MONA OFFSHORE WIND PROJECT

Mona Change Request Report

Document Reference: SCR

Document Number: MOCNSGS111

Extract from Change Request: Works Plan - Onshore (Document Reference S\_CR\_4 F02)

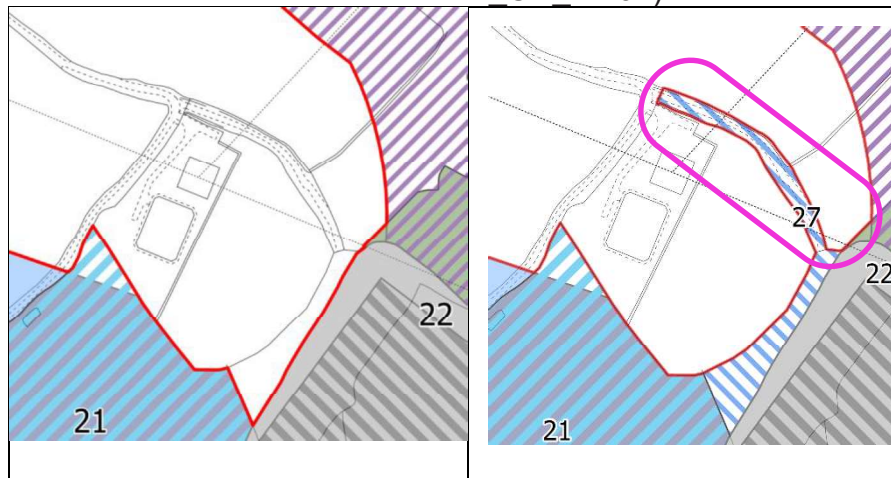
Change 1a – Order Limits change to include an existing access track to the west of the onshore substation for temporary access during onshore site preparation works

1.2.1.2 This change will result in the inclusion of a section of the existing access track at the onshore substation at grid reference SJ 01353 73277 within the Order Limits to accommodate temporary access.

1.2.1.3 This existing access track is currently being utilised by the Applicant for ongoing site survey and investigation works. This change does not involve any works or upgrades to the existing track, the track will only be used to take access to Work Nos. 21, 22 and 33 (and other works areas through Work Nos. 21, 22 and 33).

1.2.1.4 As shown on the Change Request: Works Plan - Onshore (Document Reference S_CR_4 F02), Change 1a will become part of Work No. 27.

Extract from Change Request: Works Plan - Onshore (Document Reference S\_CR\_4 F02)

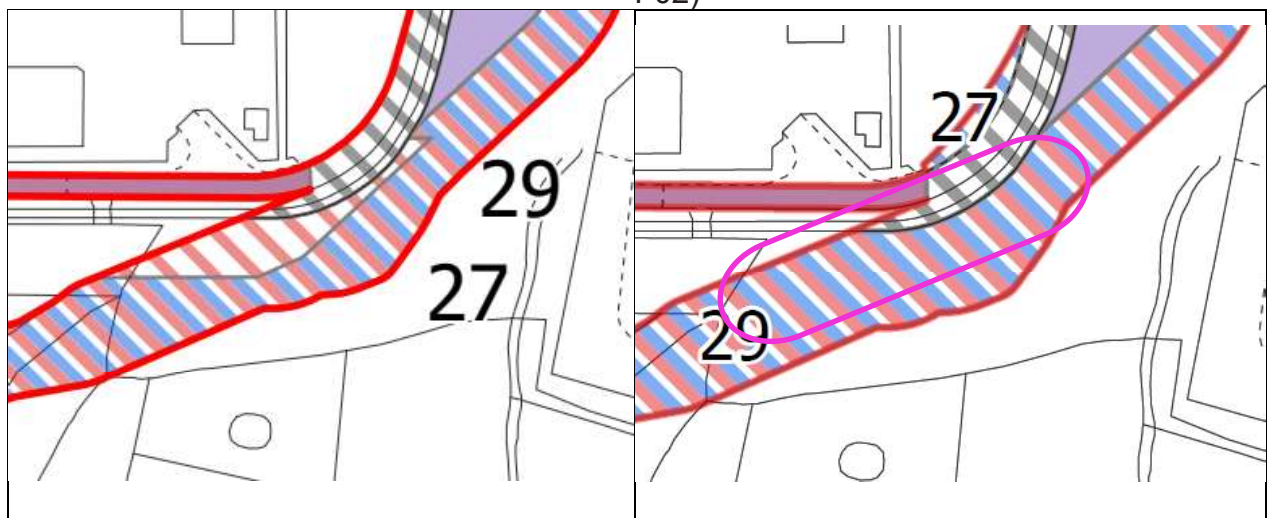
Change 00 – Amendment to Work No 000 to widen the temporary onshore substation construction access road at grid reference S 01 000 000 1 0 0 y including a small area of additional land to the area identified for Work No 000 approximately 000m within the existing Order Limits. This land is currently identified as part of the permanent onshore substation access Work No 0000 only.

1.2.2.4 The Applicant’s preliminary design work has identified additional space is needed along the temporary construction access road in this area to facilitate the AIL’s whilst ensuring adequate space for the fencing requirements outlined in the Outline Fencing Management Plan (REP2-048).

Extract from Works Plans – Onshore (AS-003) Extract from Change Request: Works Plan - Onshore (Document Reference S\_CR\_4 F02)

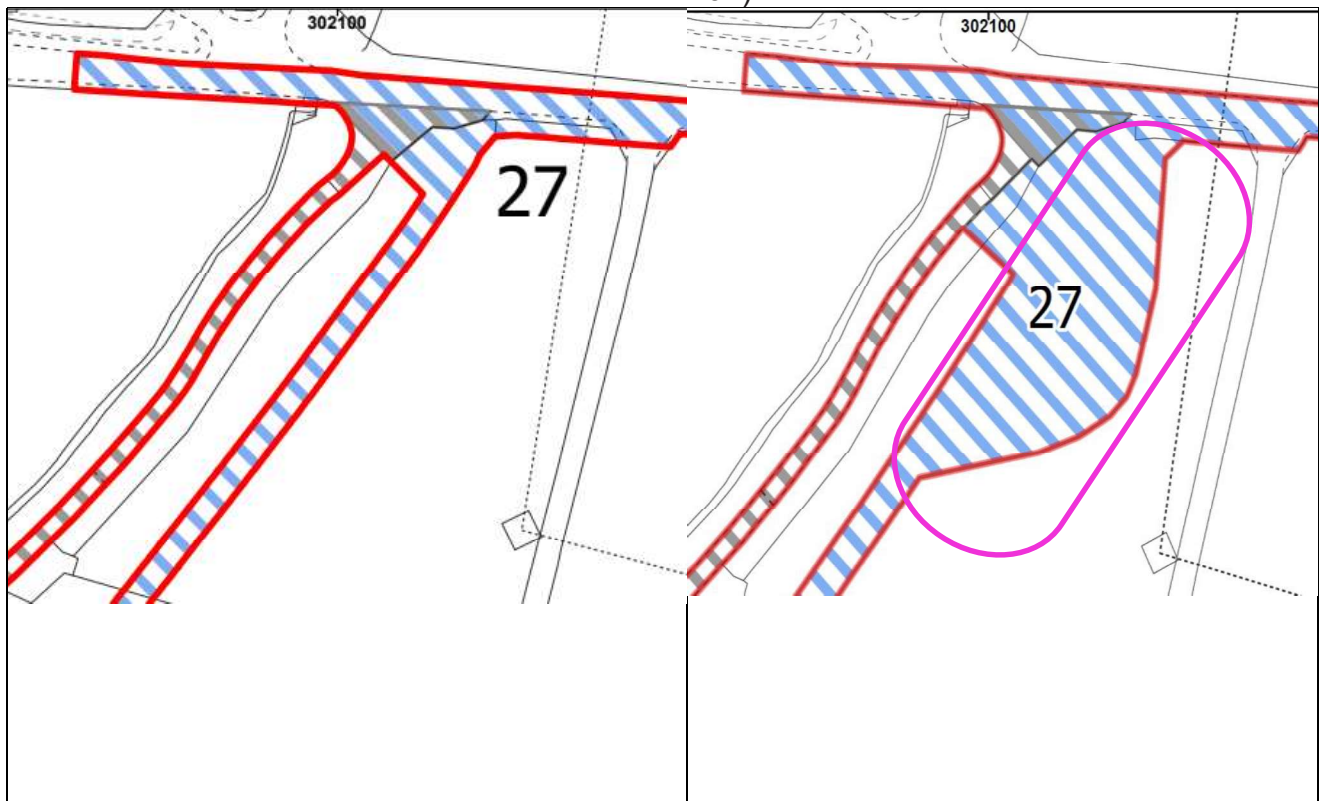
1  Change  – Amendment of the proposed Order Limits to include additional land adjacent to the onshore substation construction access  ellmouth to accommodate a temporary construction drainage attenuation  basin

1.2.3.1 This change results in a widened temporary onshore substation construction access road (eastward) to accommodate an additional temporary Sustainable Urban Drainage System (SuDS) attenuation pond at the northern extent of the onshore substation construction access road.

1.2.3.2 The additional area of land required for Change 3 amounts to approximately 2350m². Whilst this land was included within the Mona PEIR Offshore Wind Project Boundary published in April 2023, it was not included upon submission on the basis of the preliminary designs for the onshore substation construction access road. However, the Applicant’s early detailed design works for the onshore substation construction access road, including the swept path analysis outlined in Change 2 (specifically Change 2a), have identified the need for additional land take. This is in order to deliver attenuation to control the discharge of surface water during construction, in part due to the wider road outlined in Change 2a, and also from the requirement for great crested newt fencing to be deployed, likely resulting in additional drainage pathways. It is proposed to construct a temporary SuDS attenuation basin as a measure to control this additional surface water runoff. The proposed Change 3 will result in

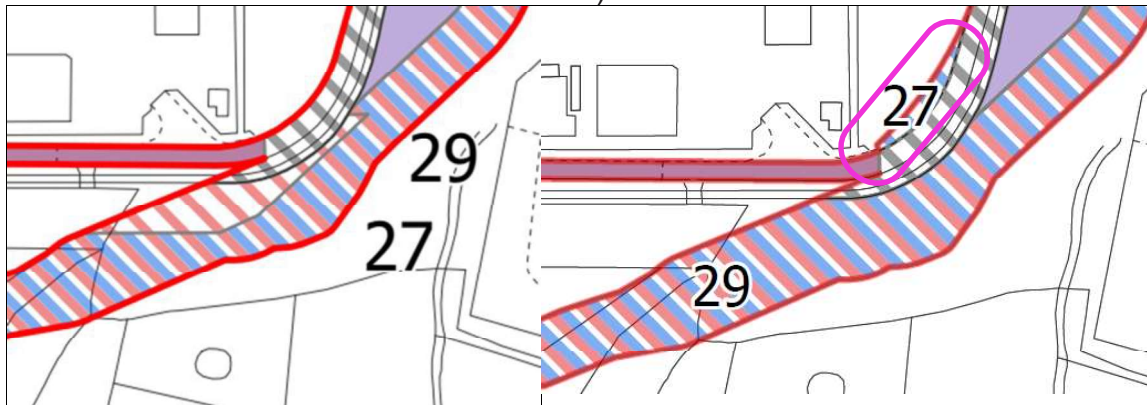
1 Change – Amendment and widening of the proposed Order Limits to include an area of land to accommodate an area of hardstanding during the construction period to allow establishment of the permanent access road

1.2.4.1 This change results in an extension of the Order Limits at grid reference SJ 01935 73551 to include the site of proposed Change 4. Proposed Change 4 will comprise a temporary area of hardstanding to be constructed immediately to the north of the existing road providing access to Bodelwyddan National Grid Substation and Gwynt y Mor Offshore Transmission Operator substation. This hardstanding will be in place during the construction period only and is necessary to facilitate the establishment of the permanent access road (Work No. 29).

1.2.4.2 In providing this temporary hardstanding, disruption to the users of the existing road will be reduced by removing the need to temporarily close the road for construction purposes.
